2 October 2018

**Response to submissions: Sydney Metro City & Southwest – Chatswood to Sydenham: MOD 5 – Blues Point acoustic shed (SSI 7400)**

Figure 2 | Section details of acoustic shed

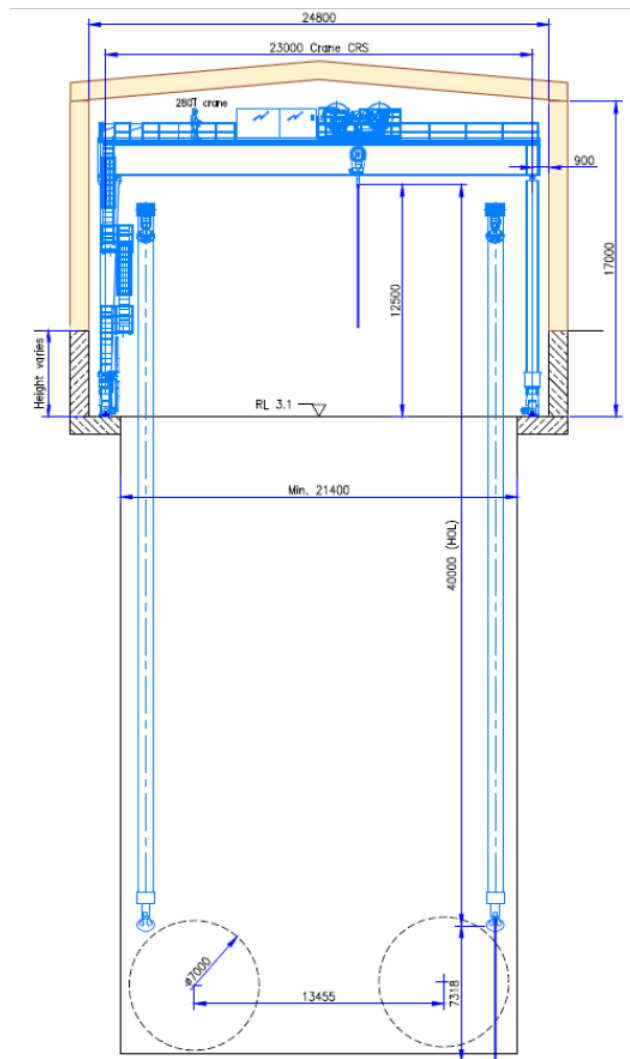
Mitigation Measures - Noise and Vibration: states that plant will be kept as far from 'receivers' (presumably people) as possible. Again, if ventilation plant is on the northern wall of the shed, it will be very close to 'receivers'. Locating it on the southern face of the shed maximises the separation distance of the plant from 'receivers'.	As per the above, the design of the acoustic shed has been revised to address this concern. The proposed louvres are now located on the eastern side of the shed, increasing the distance from the residential receivers.

As identified in Table 1, the design of the proposed acoustic shed has been revised in response to the submissions received. The louvres are now proposed to be located on the eastern side of the acoustic shed, further away from residential receivers.
